**Interested Party Reference number: 20029971**

24 January 2024

### **Sunnica Energy Development**

Drawing Number <b>60589004_ES_LSP_029D</b>	Rev <b>0</b>
---	-----------------

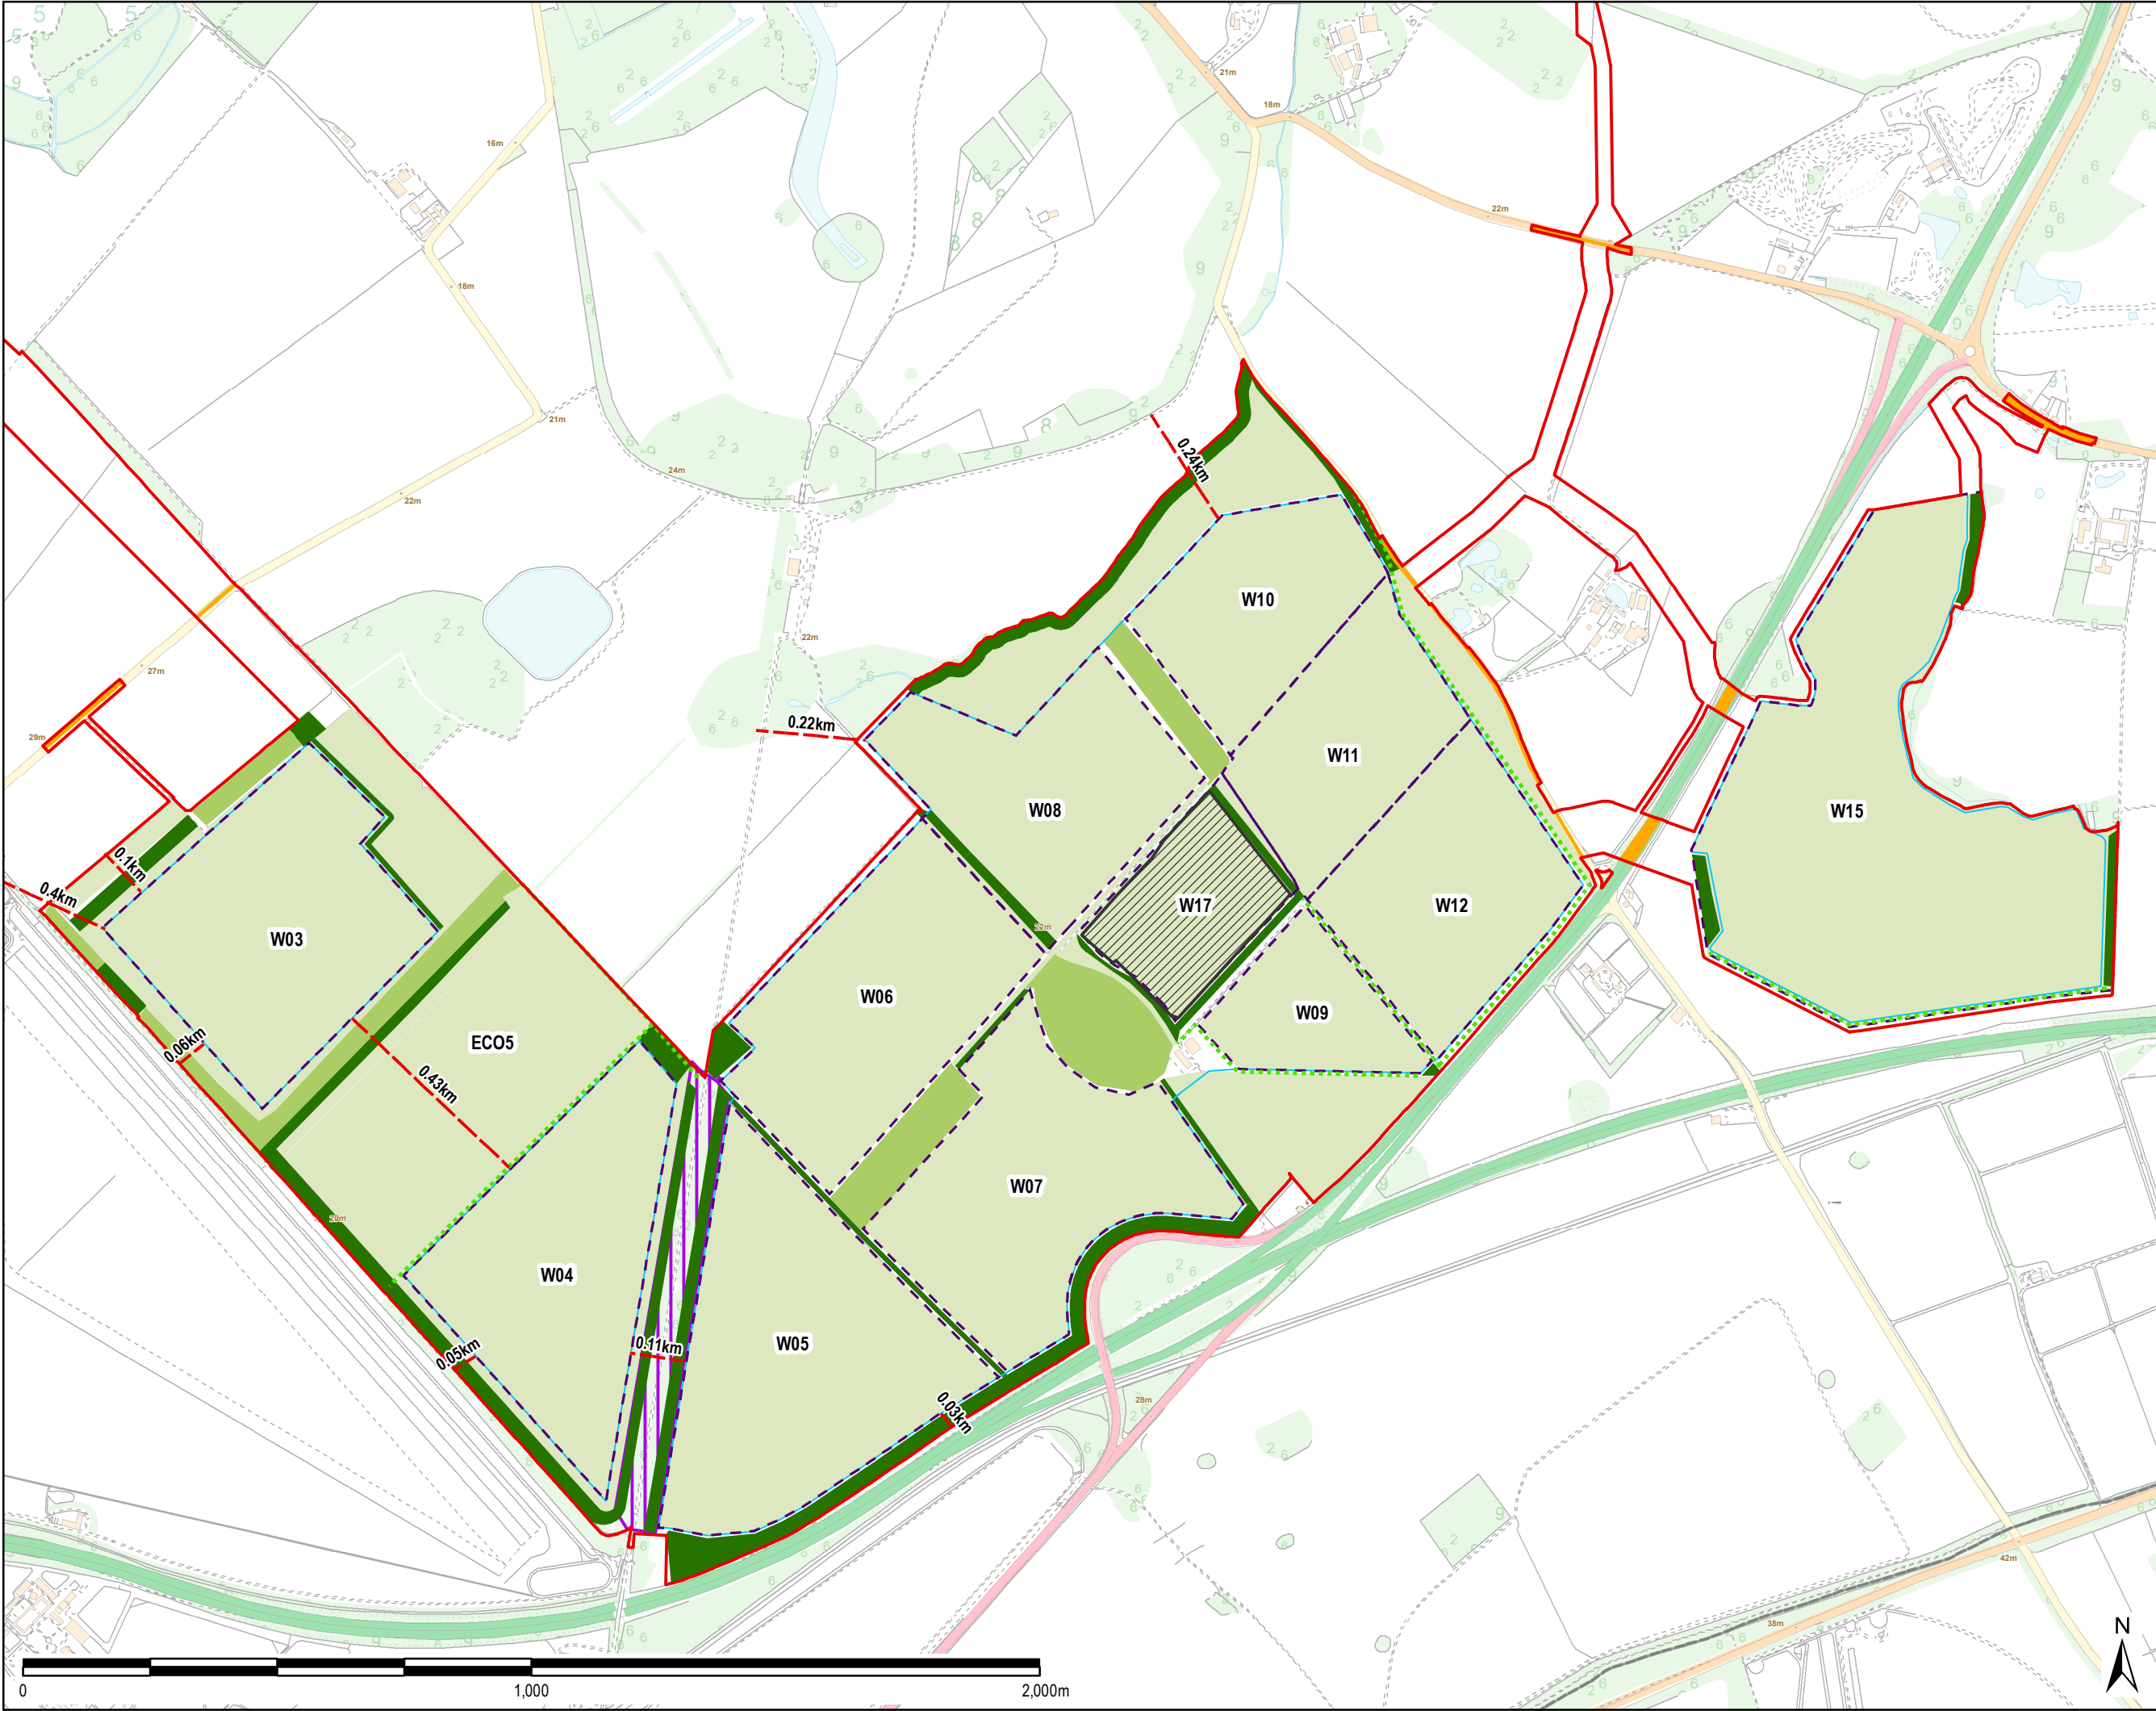
The Applicant describes the scheme design and development as being 'landscape-led'. This is not apparent from the plans.

West Site A - As an elevated site, the view over West Site A from the Limekilns cannot be hidden through planting, which the Applicant themselves have agreed.
